Locomotive Workshop, Bays 5-15

*State Significant
Development Modification
Assessment
(SSD 8449 MOD 4)*

February 2020

2 L1 - GFA - BAYS 5-15
1:500

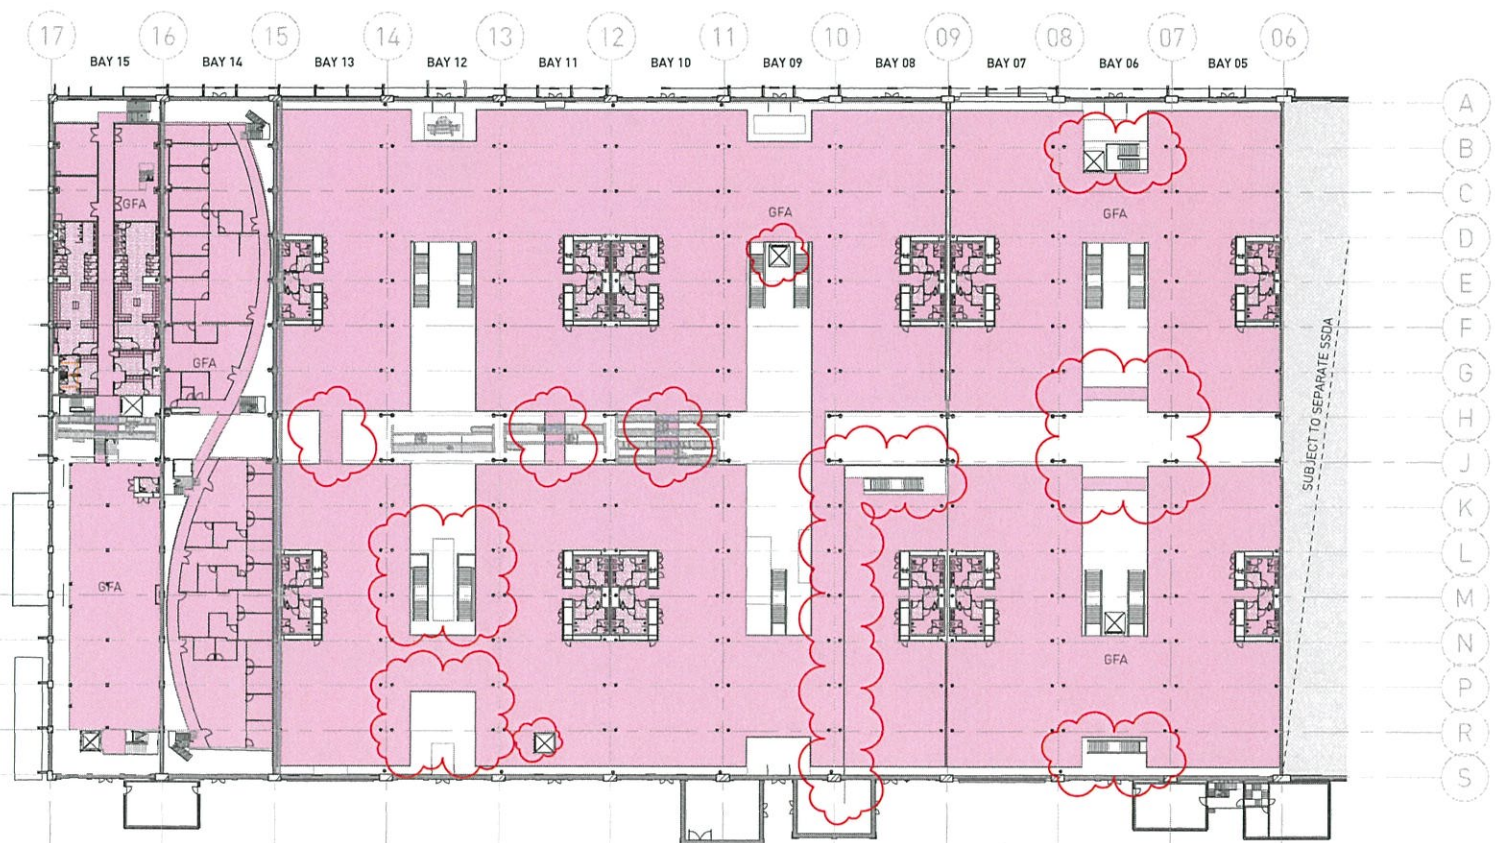
- architectural drawings for the new sliding barrier, including the door specifications, structure and materials, noting that the sliding door is located in the central spine, an area intended to be kept open to provide views through the building
- clarification on whether the access bridge in Bay 10 central is to be reconfigured or is an additional bridge.

- the sliding glazed barrier in Bay 8, while allowing for visual continuity of sightlines along the central spine, will obstruct the openness of the corridor which is free from structures and restricts public access into the central spine
- the modification to comply with the BCA is unconvincing and Council recommends an alternative design solution be explored
- the change to the access bridge in Bay 10 central remains unclear.

Council advised it was satisfied with all changes to stairs, lifts and access bridges, however noted the plans submitted with the RtS illustrate two access bridges in Bay 10 but it is unclear the location of the widened and centred access bridge outlined in the documentation.

The Department notes the most recent approved plan for Bays 5-15 (under MOD 3) provides for three access bridges on level 1, two in Bay 9 and one in Bay 12 (**Figure 9**). This proposal seeks approval to:

- reconfigure the Bay 9 bridge to the centre of Bay 10
- reconfigure the Bay 12 bridge to the centre of Bay 13
- add a new access bridge to the centre of Bay 11 (**Figure 4**).

③ SK_0851 GRID 8 GLAZING - GROUND FLOOR PLAN
1:50

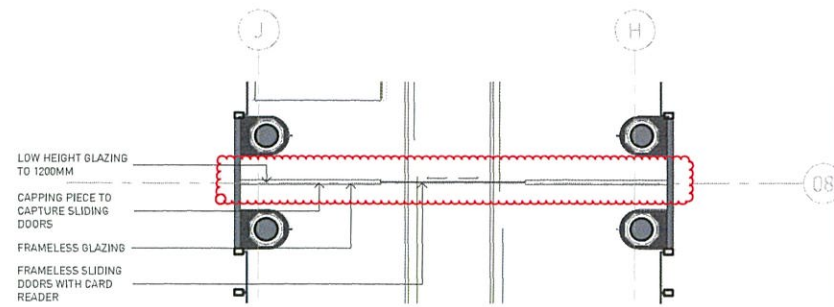
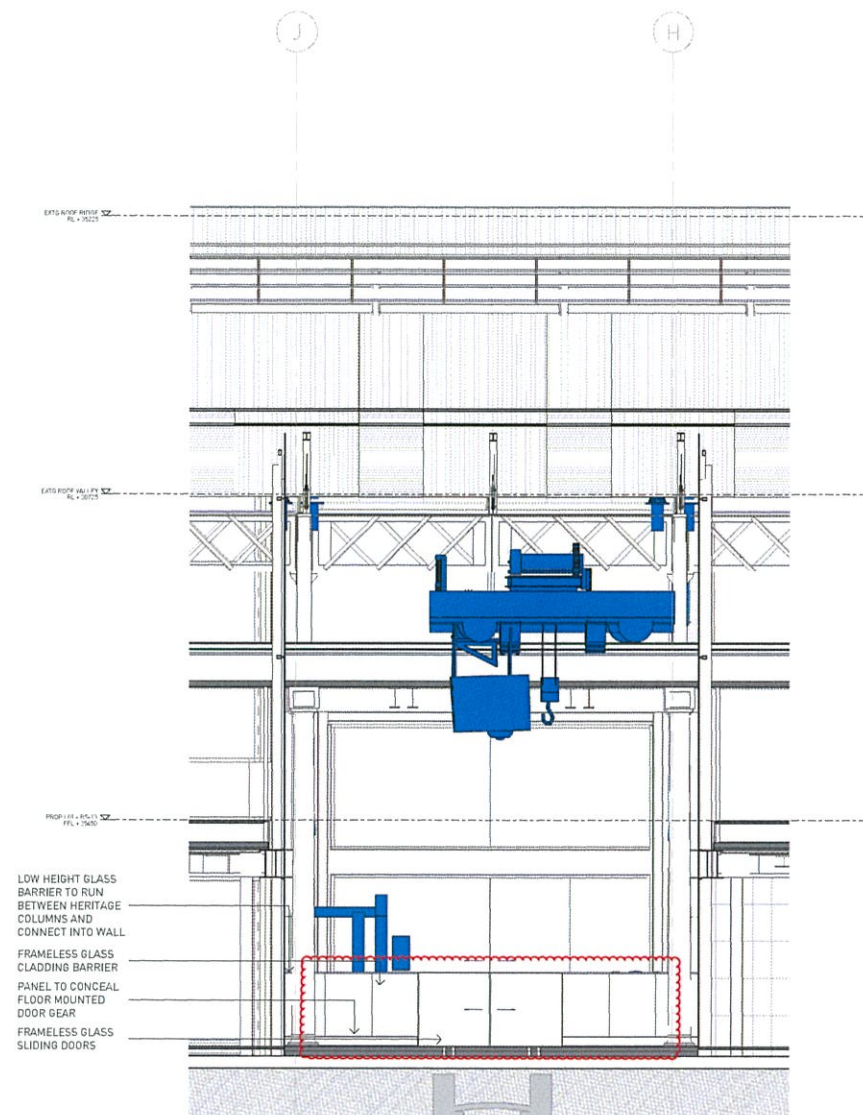
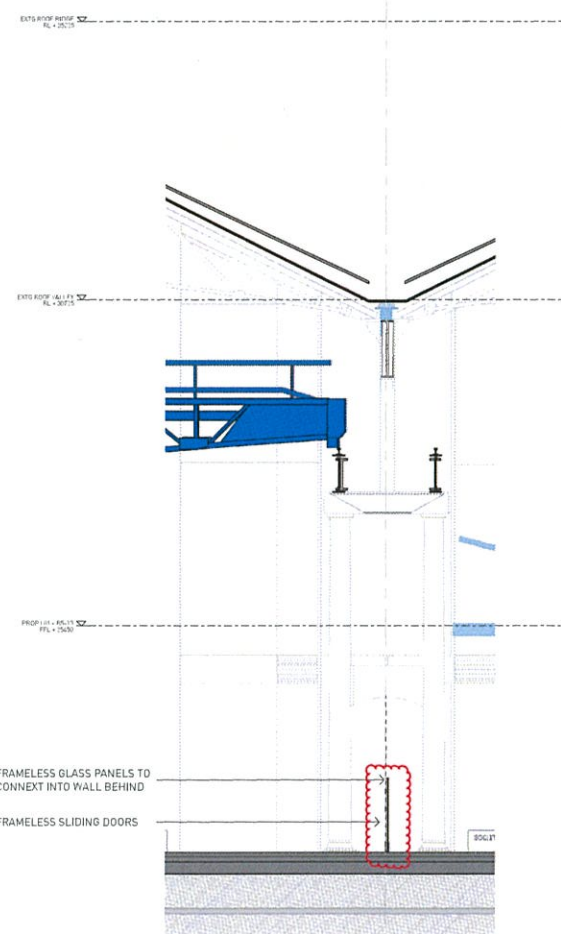
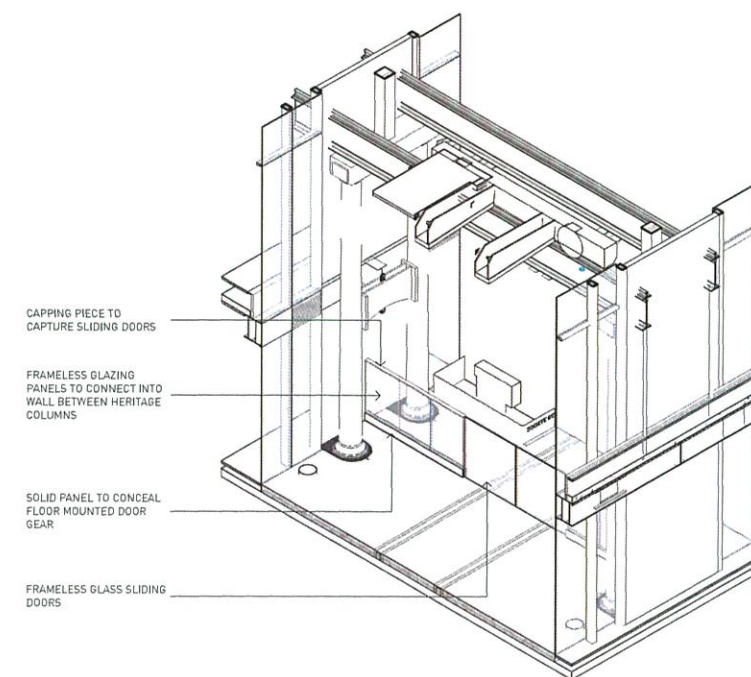
- additional justification and detail to understand the new sliding barrier, including the proximity of the proposed door to the approved sliding door at gridline 9 and potential impact to views along the central spine zone
- provide further detail of the relocated intertenancy wall, including the interaction between the new wall and roof truss structure.

- the documentation does not adequately demonstrate how it complies with BCA and fire engineering requirements
- it will provide another visual and physical barrier along the central spine zone, which was a critical corridor to the original functioning of the building
- it prevents public access to two significant moveable heritage items.

- amended sliding glazed barrier design, reducing the height to 1.2 m
- additional Fire Engineer and Building Compliance statements
- details of consultation on the amended design with Council and Heritage NSW.

Council reviewed the additional information and advise it accepts the requirement for a sliding door at gridline 8 for public safety and fire compliance under the BCA and considers the low height frameless glass barrier a reasonable outcome.

Heritage NSW reviewed the additional information and were satisfied the revised design to the sliding barrier adequately addresses its concerns and is considered acceptable.

- the glazed barrier has a low height (1.2 m), will continue to allow for views along the central spine of the Locomotive Workshop (**Figure 7**) and it is visually less intrusive than options such as the creation of a corridor

- the barrier is critical to the fire safety strategy for the Locomotive Workshop, compliance with the BCA and to ensure the safety of members of the public
